**MODIFICATION REQUEST:
MP10_0016 MOD 3**

***Scottish Hospital Seniors Housing and
Care Facility***

Environmental Assessment Report
Section 75W of the *Environmental Planning and
Assessment Act 1979*

May 2017

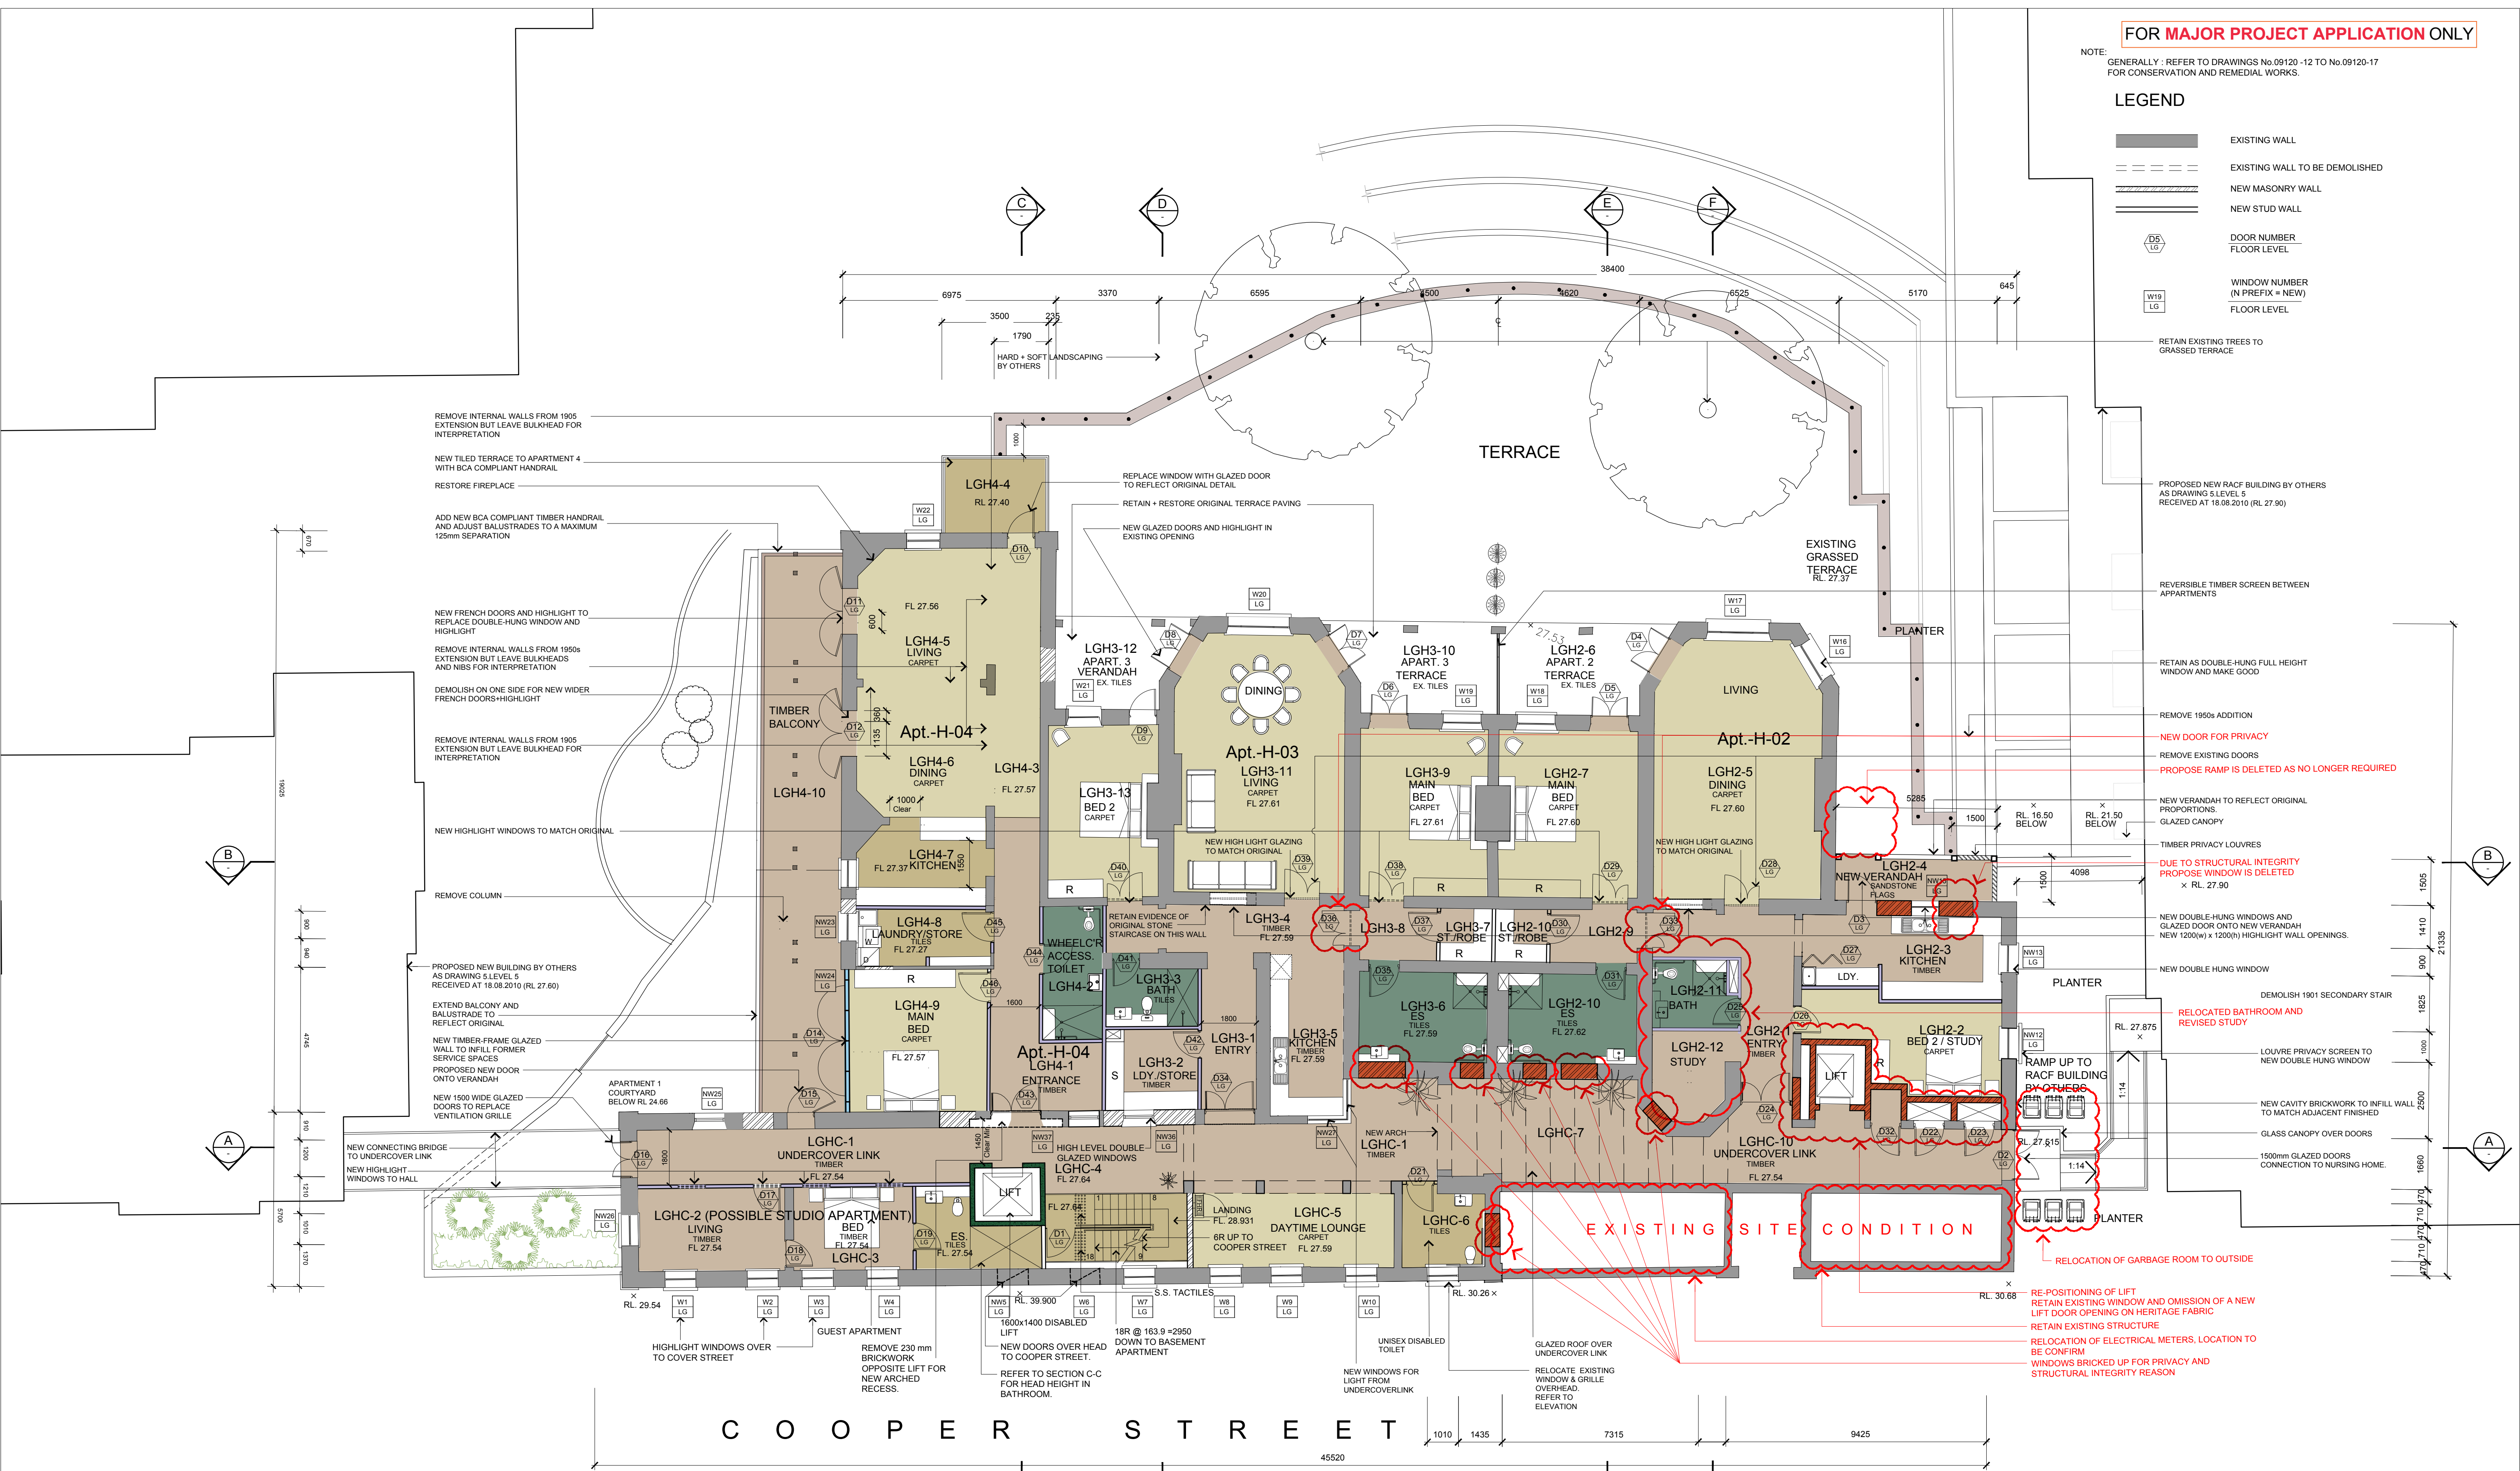
The Proponent is seeking to relocate the garbage bin store from within the building to an external location to the east of the building (**Figure 3**). The Proponent contends that the garbage bin store must be relocated as recent investigations have identified that the current approved location of the bin store is not structurally stable, and requires additional underpinning.

All three public submissions raised concerns about the potential adverse impacts of the external garbage bin store on the amenity of the surrounding area, including visual, odour and traffic (garbage collection) impacts. The Department also requested that the Proponent address:

- how the external garbage bin store can be visually screened, while being sympathetic to the architecture of the Scottish Hospital building; and
- design and/or management measures to mitigate amenity impacts of the garbage bin store on neighbouring properties, such as odour.

The Department has carefully considered the proposed relocation of the garbage bin store, having particular regard to the concerns raised in submissions and the Proponent's response to those concerns. The Department supports the relocation of the garbage bin store, subject to the provision of a bin enclosure with roof (Option 2), for the following reasons:

- the timber design of the bin store enclosure is sympathetic to the heritage building. The structure is discreet, can be easily distinguished from the existing fabric and easily reversed should this be required;

- the bin store enclosure is unlikely to result in adverse visual impacts when viewed from Cooper Street and the surrounding properties, and in particular from properties to the south of Cooper Street, as the bin store is located approximately 3m below street level, visually screened by the boundary fence on Cooper Street (**Figure 9**) and views from the east and south east are screened by the approved RACF building;

- the roof will screen the bin store enclosure from the ILUs in the Scottish Hospital building;
- the bin store will not generate any traffic impacts along Cooper Street, noting that the bins will be moved to the main waste store on Brown Street for collection; and

- the proposed roof structure over the bin store area and the removal of bins at least twice weekly will minimise any potential odour impacts.

The Department recommends a condition requiring that the design and materials of the boundary fence in this location provide a suitable visual screen when viewed from Cooper Street.

DRAWING TITLE
Heritage Building - Level 6
DRAWING No
DA 432

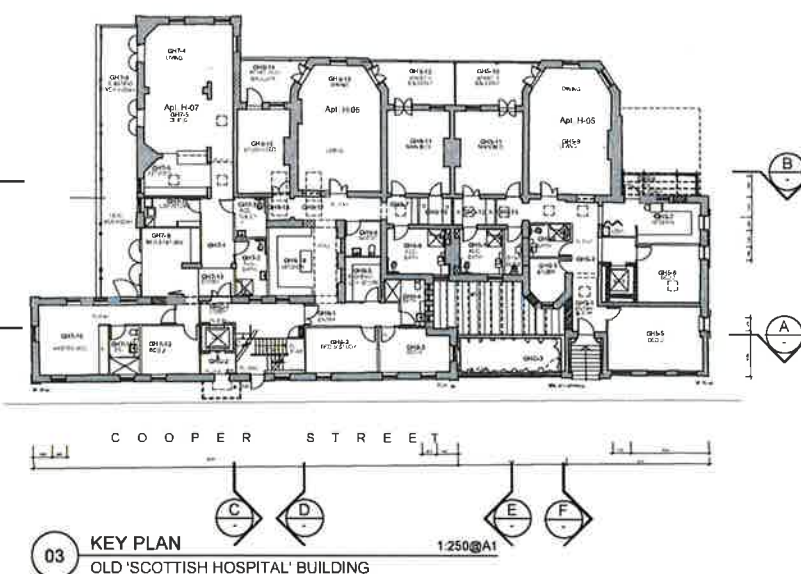
The proposal seeks to infill an existing window (W16 G) in the bay feature on Level 6 facing Cooper Street (**Figure 7**). The Department notes this area is identified in the CMP as having high heritage significance, and that the window is visible from Cooper Street. Noting the visual prominence of this bay feature and window fenestration to the street, the Department recommends that the window be retained. Notwithstanding the structural reasons for infilling the windows, the Proponent has advised that the retention of this window can be achieved.

The Department therefore recommends a condition that amended plans showing the retention of window WG6 on Level 6 be submitted to the satisfaction of the Principal Certifying Authority prior to issue of the relevant Construction Certificate.
